From: Amanda Scholes on behalf of Planning.Responses
Sent: 06 September 2017 09:46
To: Planning Scanning
Subject: FW: Response: Planning Consultation EP/111/17/HH - 21 Worthing Road, East Preston, BN16 1AT
Attachments: GIS.pdf; 05.09.17 PLAN-019476.pdf

PLAN-019476

Proposal: Rear extension. Revision of previously approved EP/68/16/HH.
Site: 21 Worthing Road, East Preston, BN16 1AT.
EP/111/17/HH

Scales: **1:500** No: **1887/01/05/A**

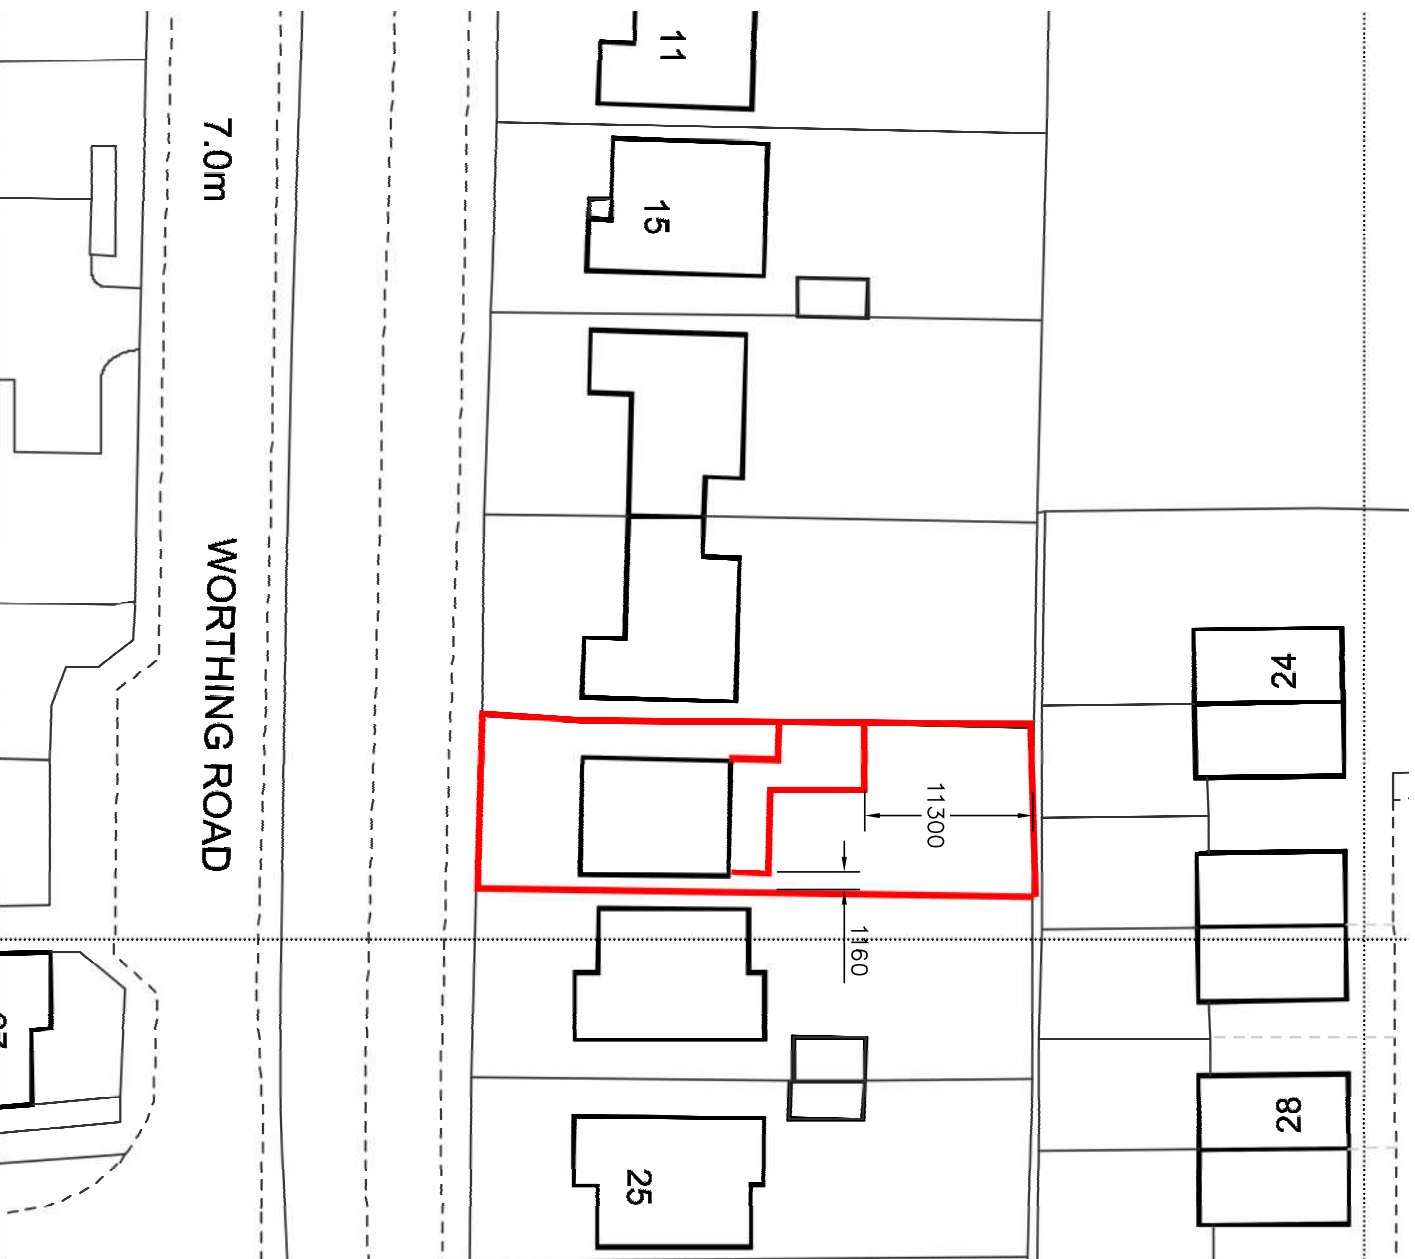
The submitted plan shows a sewer serving neighbouring property and crossing the proposed site at the rear of the existing building (not shown on our records). It appears that the developer is intending to divert and/or build close to a public sewer. Building close/over a "public sewer" is not normally permitted by Southern Water. An investigation of the sewer is required to ascertain its condition, the number of properties served, and potential means of access, before any decision can be made as to whether it would be acceptable for the proposed development close to the sewer. Part H of the Building Regulations dictates that the matter is determined by the sewerage undertaker – in this case Southern Water.

The applicant is advised to discuss the matter further with Southern Water, Sparrowgrove House Sparrowgrove, Otterbourne, Hampshire SO21 2SW (Tel: 0330 303 0119) or www.southernwater.co.uk.
